EL PASO COUNTY PLANNING AND COMMUNITY DEVELOPMENT DEPARTMENT

GRADING AND EROSION CONTROL PLAN CHECKLIST ROLLING HILLS RANCH FILING 2

Revised: July 2019

ROLLING HILLS RANCH FILING 2
AT MERIDIAN RANCH
GRADING/EROSION CONTROL PLAN
GRADING LAYOUT

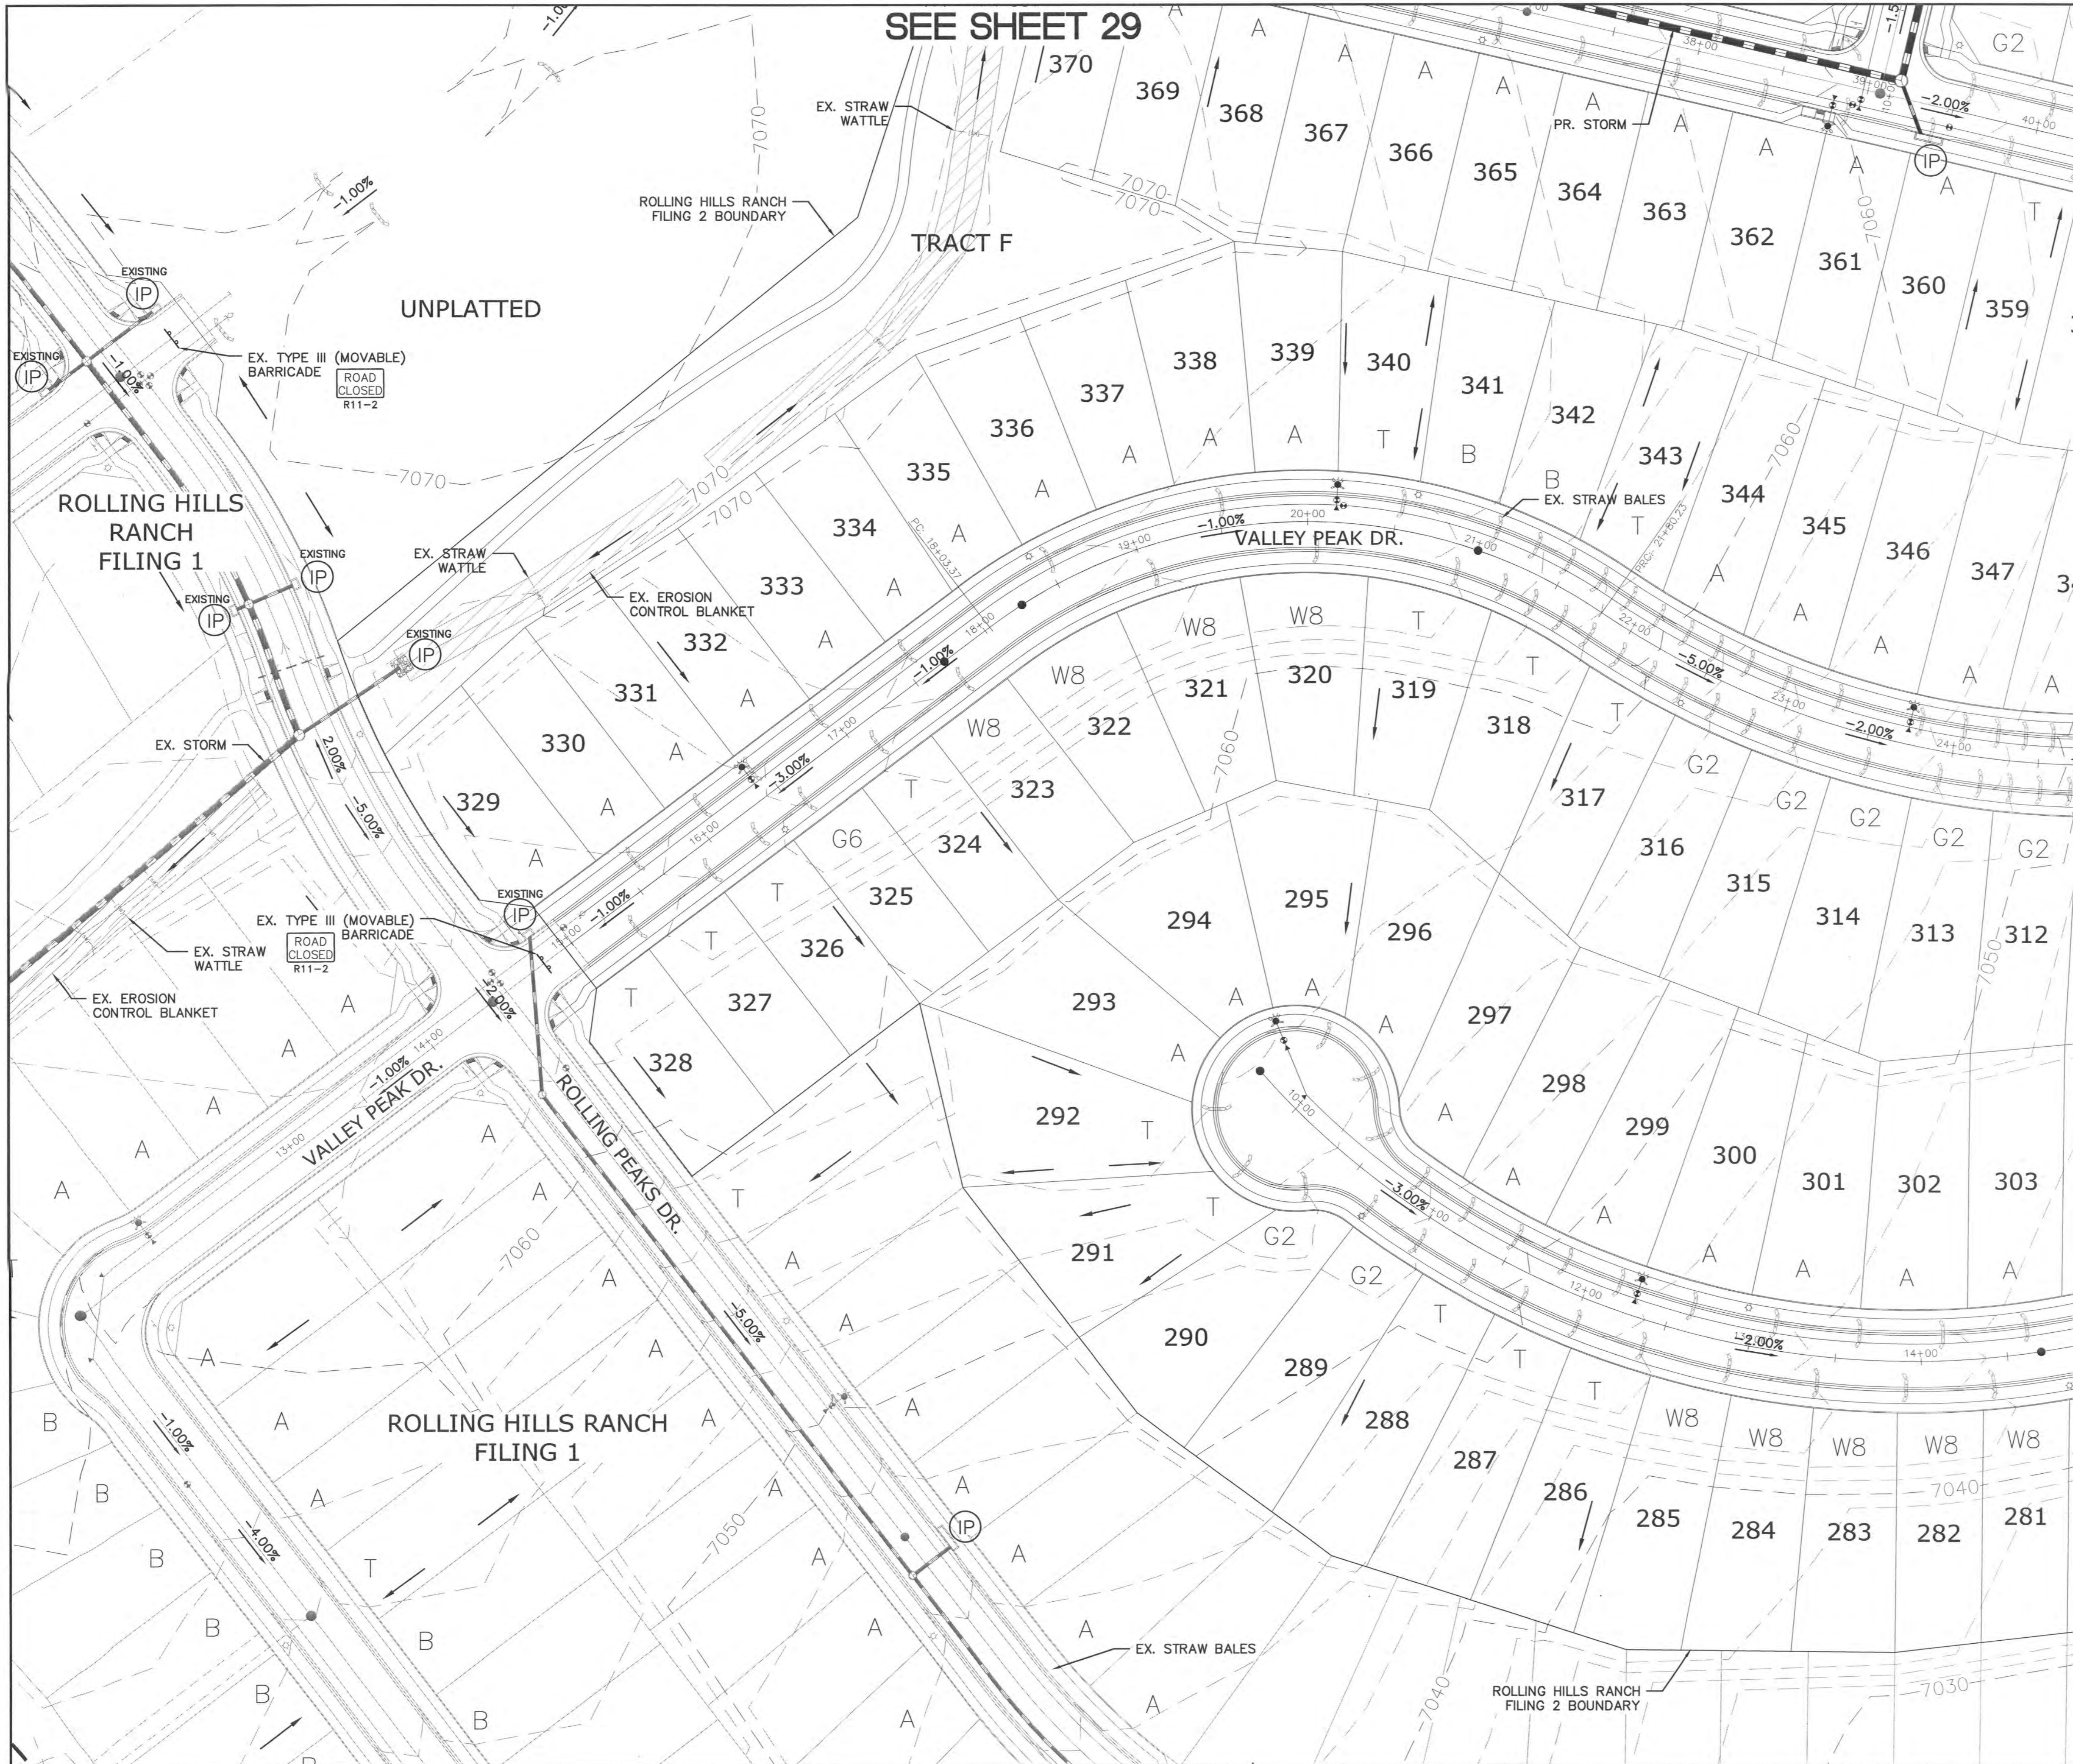
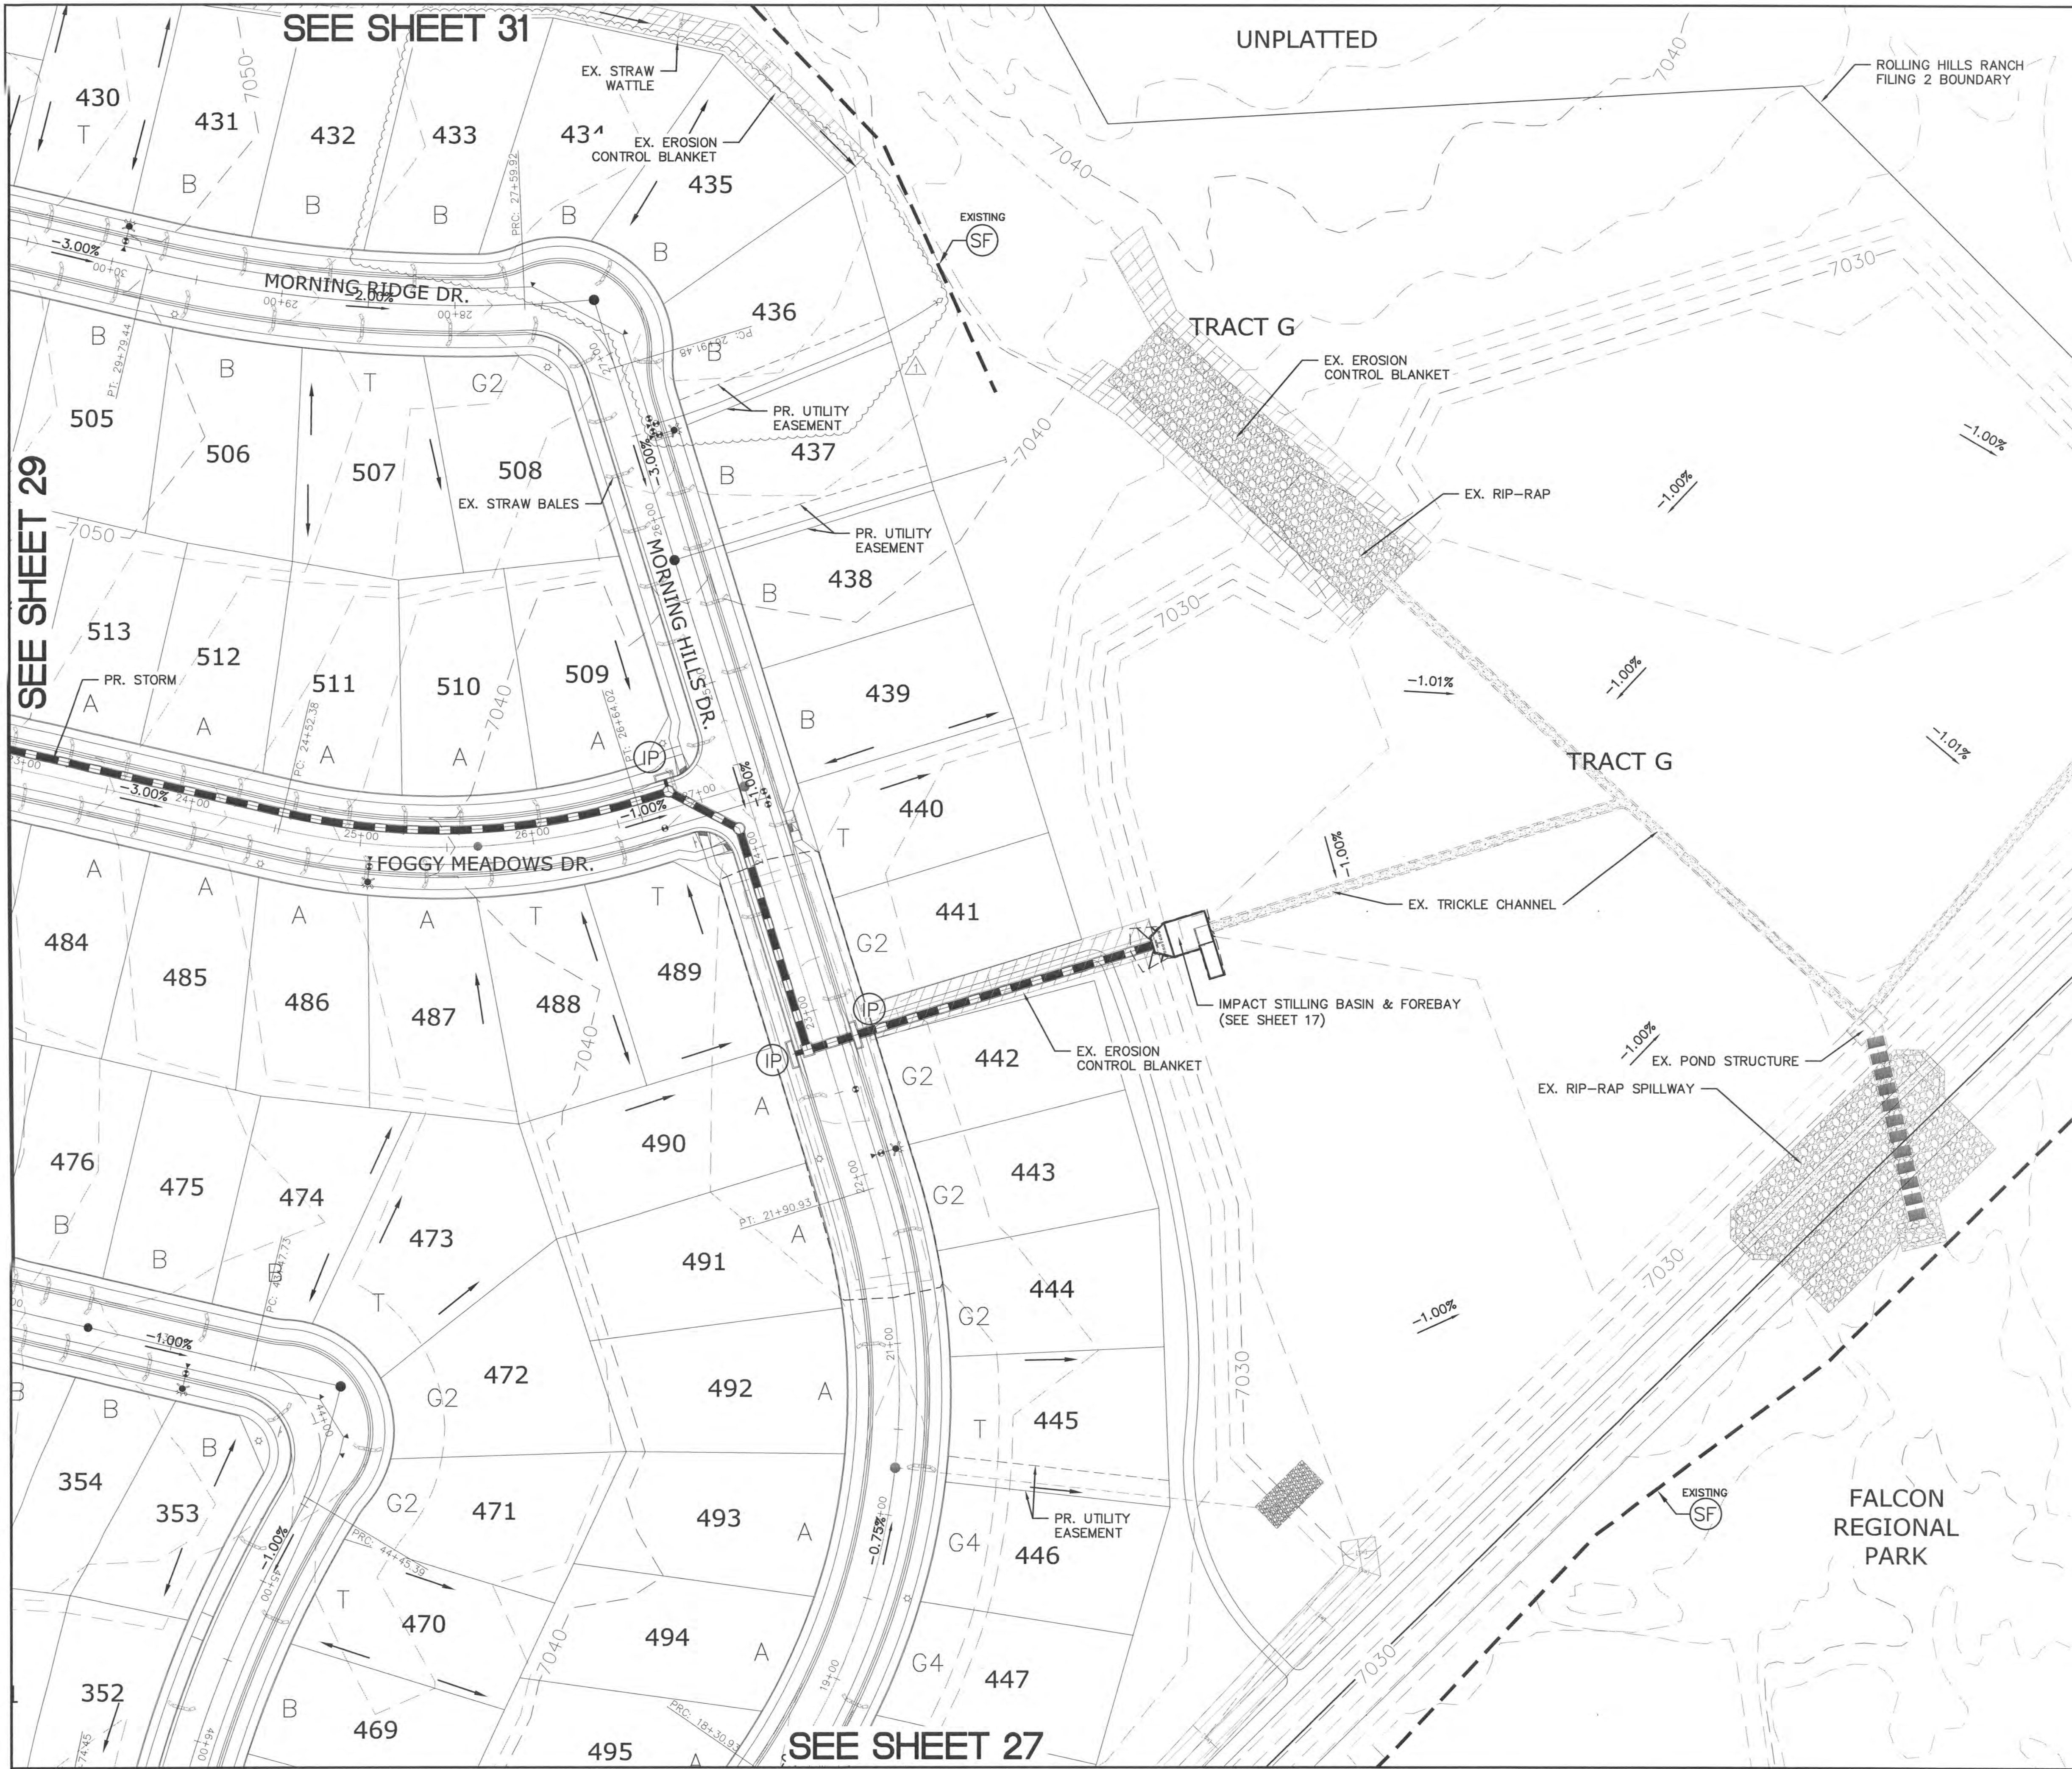
v	All proposed temporary construction control measures, structural and non-structural. Temporary construction control measures shall be identified by phase of implementation to include "initial," "interim," and "final" or shown on separate phased maps identifying each phase.	X	X
w	Vehicle tracking provided at all construction entrances/exits. Construction fencing, barricades, and/or signage provided at access points not to be used for construction.	X	✓
x	Temporary sediment ponds provided for disturbed drainage areas greater than 1 acre.	X	N/A
y	Dewatering operations to include locations of diversion, pump and discharge(s) as anticipated at time of design.	n/a	N/A
z	All proposed temporary construction control measure details. Custom or other jurisdiction's details used must meet or exceed EPC standards.	X	✓
